# **EL PASO COUNTY PLANNING AND COMMUNITY DEVELOPMENT DEPARTMENT**

## **STORMWATER MANAGEMENT PLAN CHECKLIST**

**SF-20-014 and EGP-20-004**

### GRADING AND EROSION CONTROL PLAN

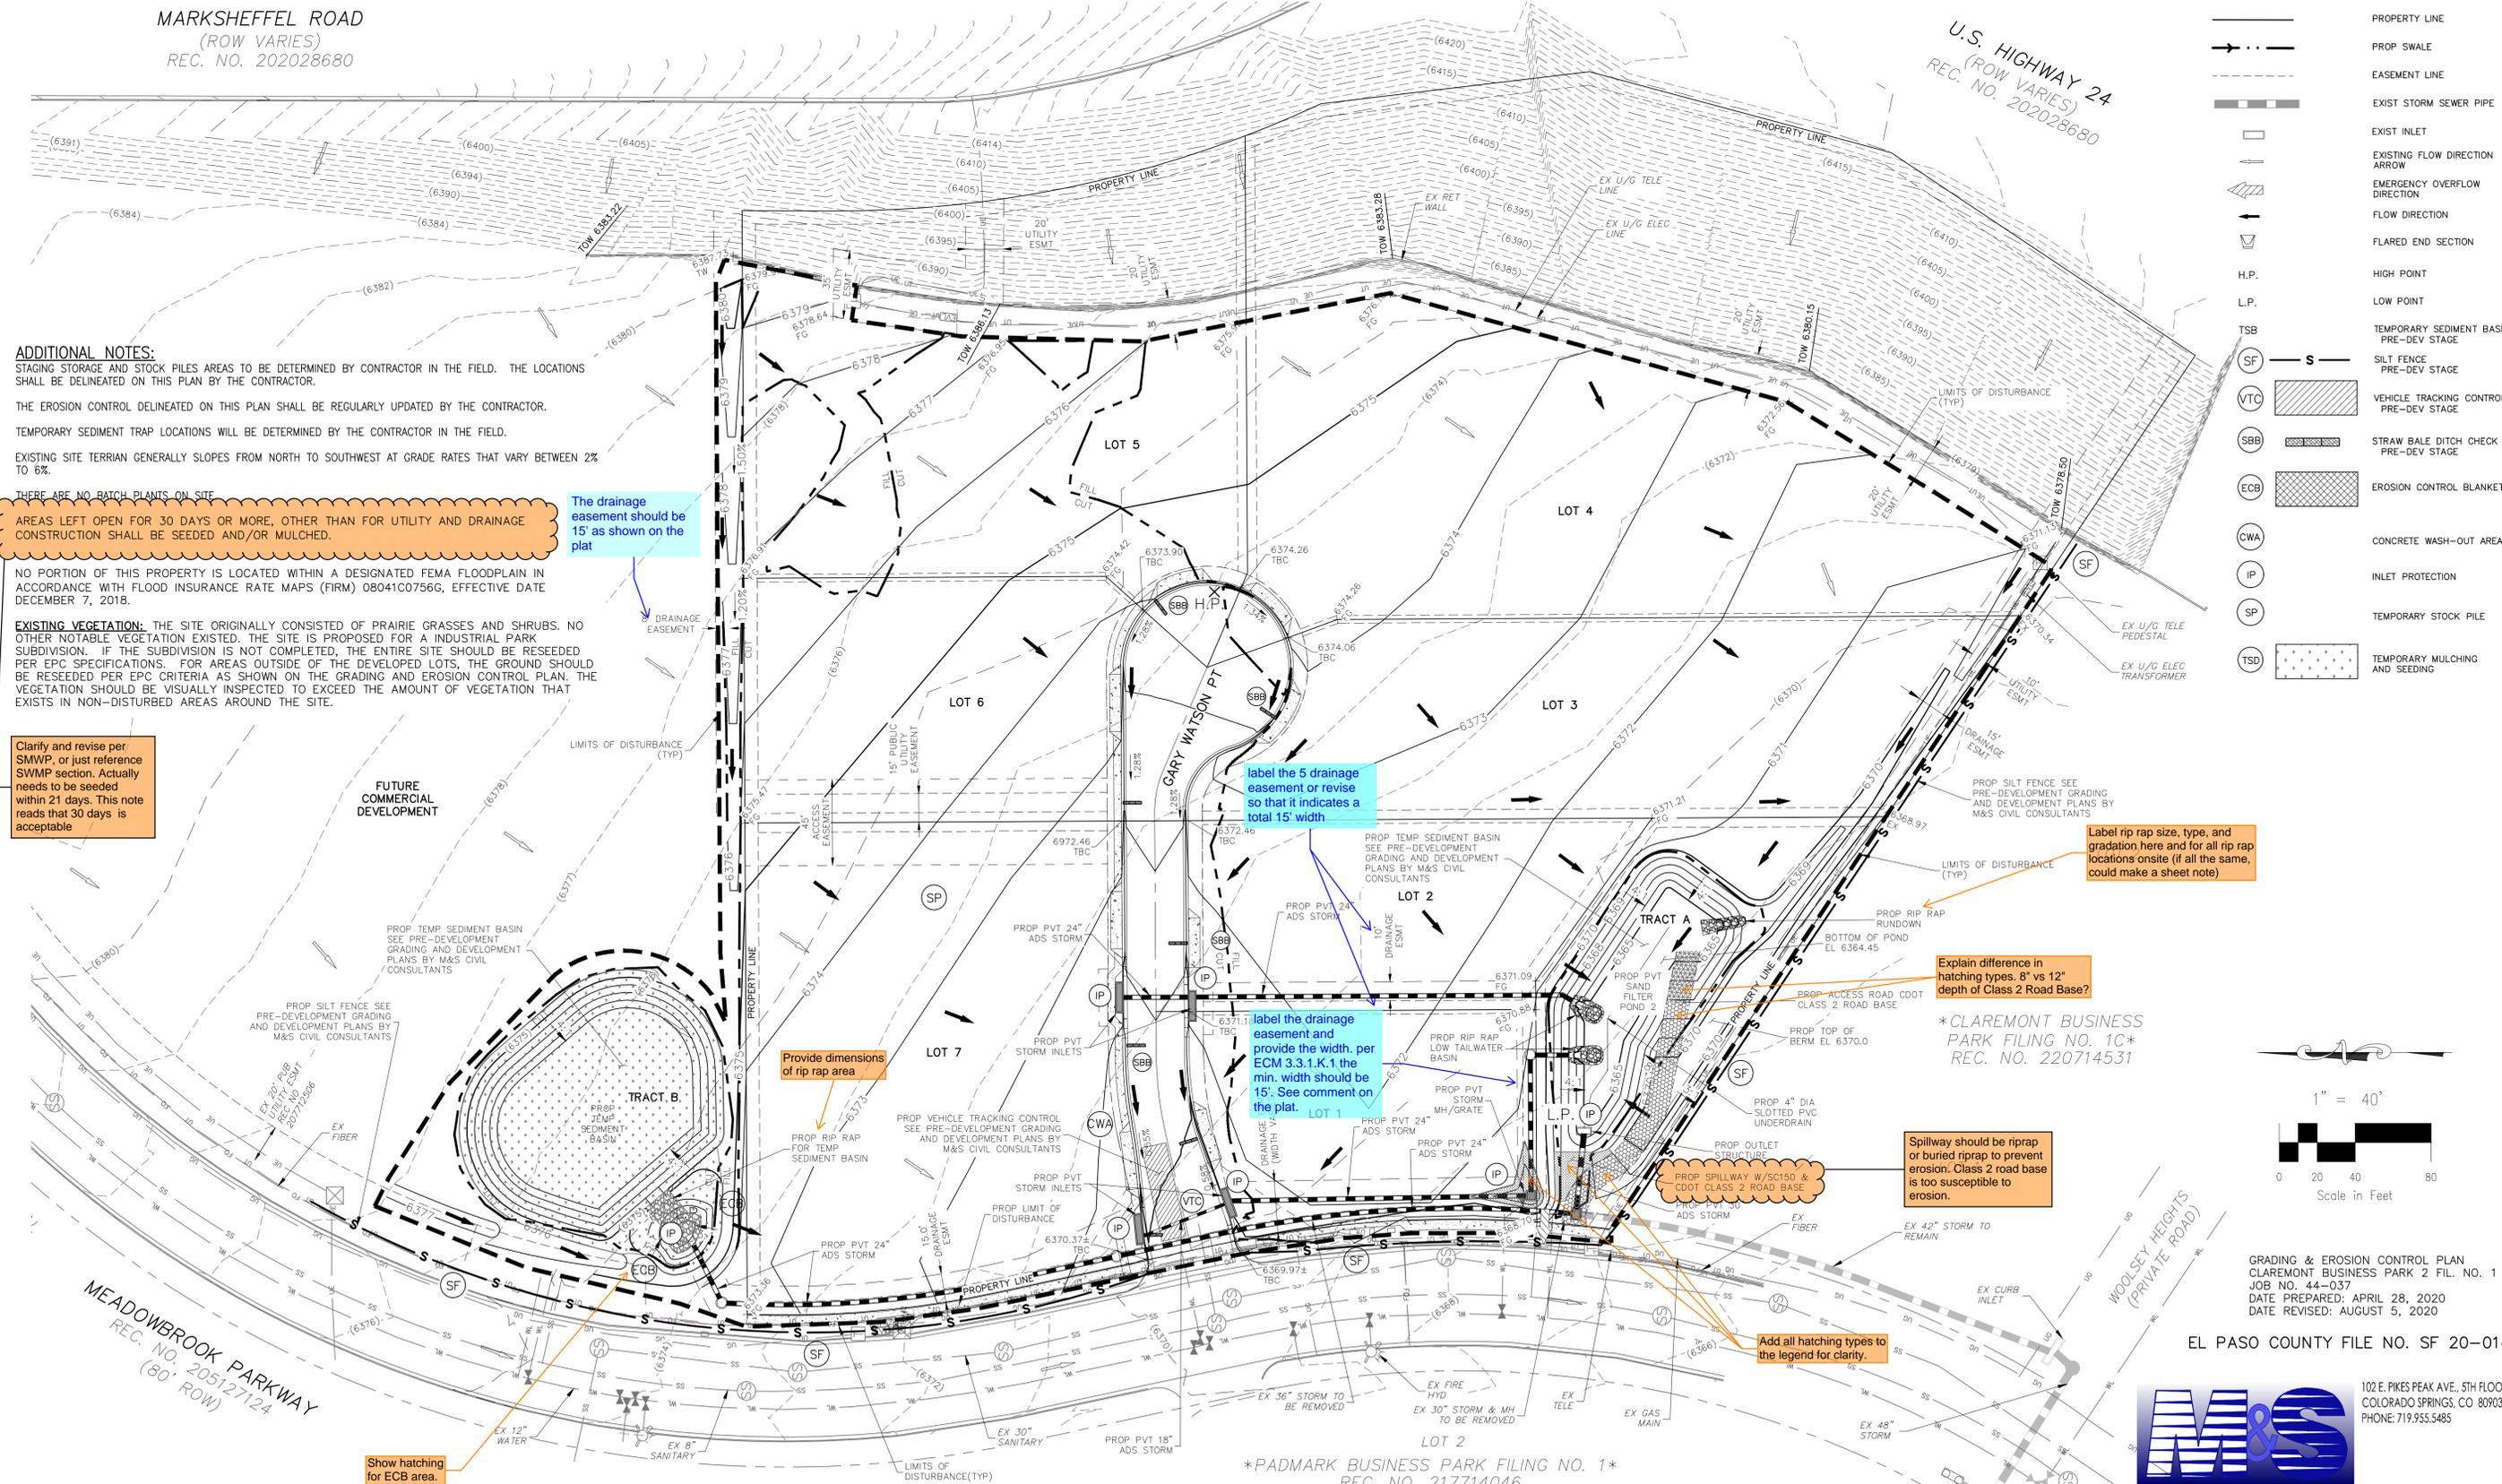
Applicant	PCD
17	SWMP Map to include:		
17a	construction site boundaries <b>Note for Limits of Disturbance and Construction line</b>	X	X
17b	flow arrows to depict stormwater flow directions	X	✓
17c	all areas of disturbance	X	✓
17d	areas of cut and fill	X	✓
17e	areas used for storage of building materials, soils (stockpiles) or wastes	X	✓
17f	location of any dedicated asphalt / concrete batch plants	N/A	✓
17g	location of all structural control measures	X	✓
17h	location of all non-structural control measures	X	✓
17i	springs, streams, wetlands and other surface waters, including areas that require maintenance of pre-existing vegetation within 50 feet of a receiving water	N/A	✓
18	Narrative description of all structural control measures to be used. Modifications to EPC standard control measures must meet or exceed County-approved details.	X	✓
19	Description of all non-structural control measures to be used including seeding, mulching, protection of existing vegetation, site watering, sod placement, etc.	X	✓
